Recommendation Report for Planning Permission for Works or Extension to a Dwelling

REF NO: P/140/21/HH

LOCATION: 6 Lion Road
Pagham
PO21 3JZ

PROPOSAL: Detached annexe

sheet 1 of 1

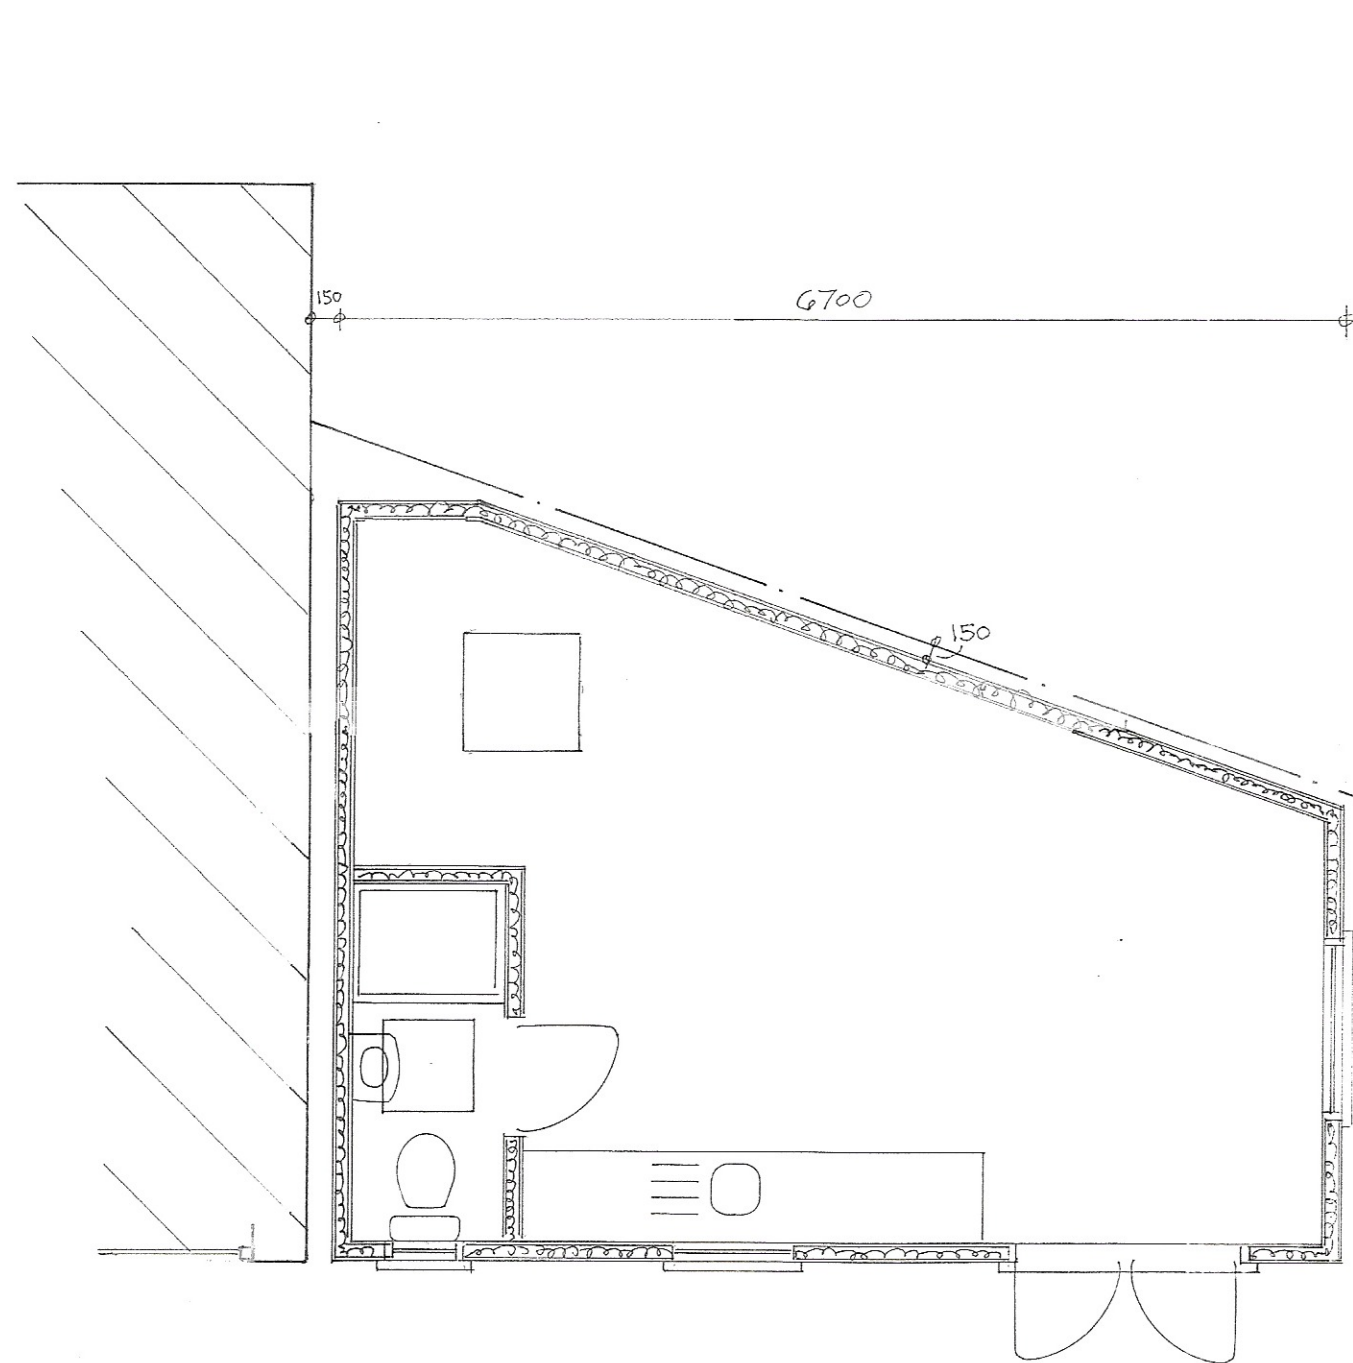
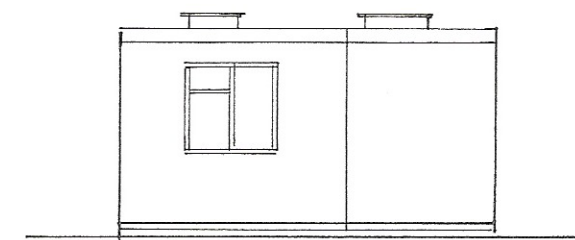
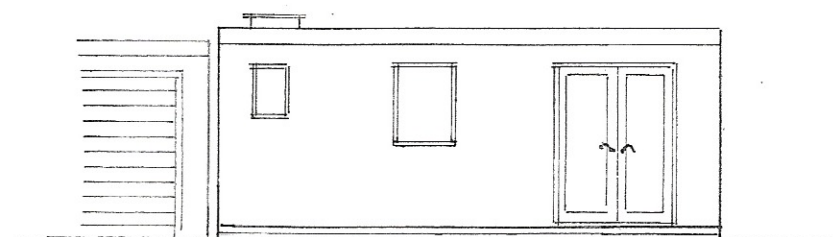
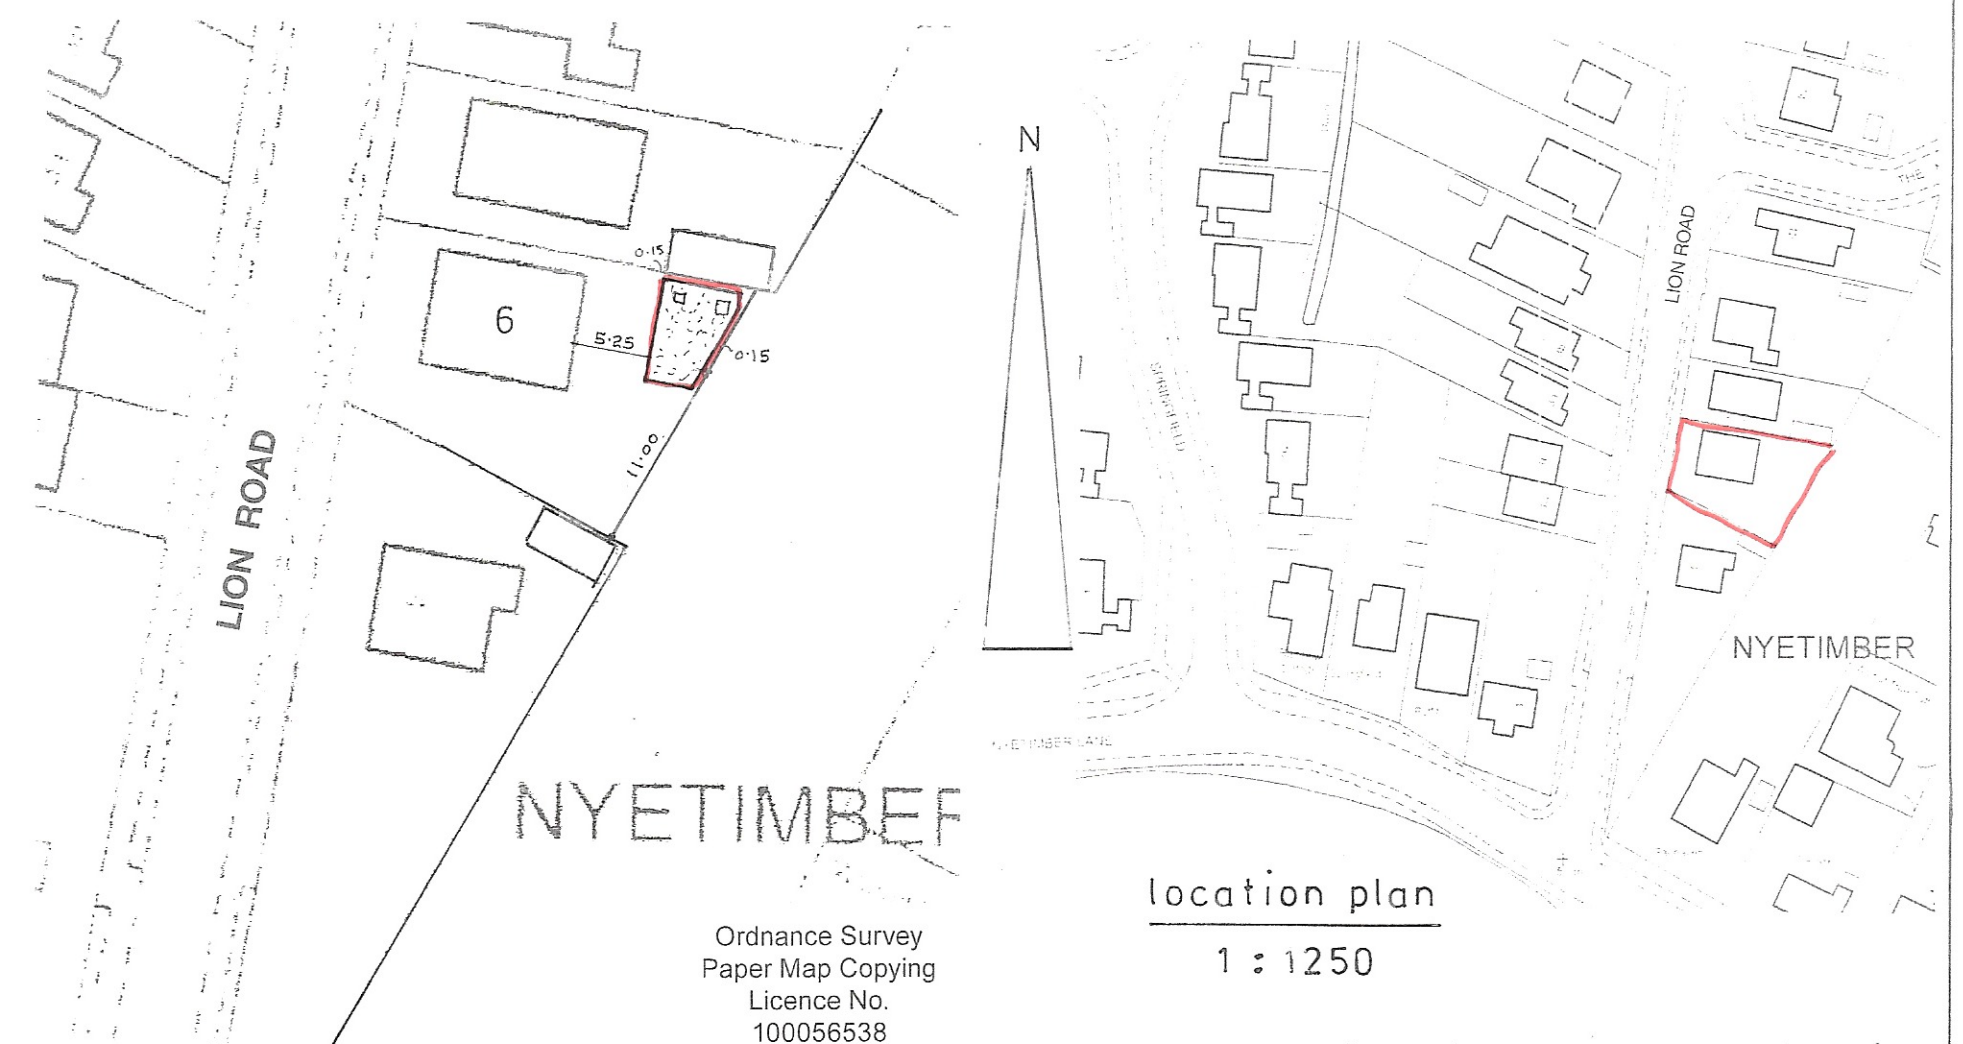
Pagham Parish Council:- no objection although concern raised that it was abutting the boundary and use has not been specified.

The proposal seeks to provide a detached single storey outbuilding for use as habitable accommodation. The proposal will be to the rear garden of the property is not visible from the wider area. It will be single storey and is fairly modest in size with a depth of 5m and width of 6.6m which runs at an angle along the boundary. It will have flat roof with 2 rooflights.

White cladding is proposed. Cladding is not present on the dwelling and the material will be a new addition. However, being to the rear of the property and not visible from the wider area, its use is not considered to result in harm upon the appearance of the street scene.

The outbuilding will have a height of 2.8m.

Due to the location and height of the structure, it is not considered to result in adverse overbearing or overshadowing on neighbouring properties. To the north side, the outbuilding will run alongside a garage located to the neighbouring boundary. To the rear/east elevation of the outbuilding, there is a hedge of approximately 2m in height with a small fence. Due to the height and siting of the boundary treatment, this restricts views of the development from the property to the rear which features a large rear garden and is not considered to result in harm.

There will be one window to the south elevation although with 11m retained to the boundary, views are predominately over the garden of the host dwelling. There will be windows and access doors to the west which will face towards the host dwelling. With the proposal at single storey to the rear garden, it not give rise to adverse overlooking.

A condition will be included to ensure that the use remains ancillary to the host dwelling and it does not form an independent dwelling.
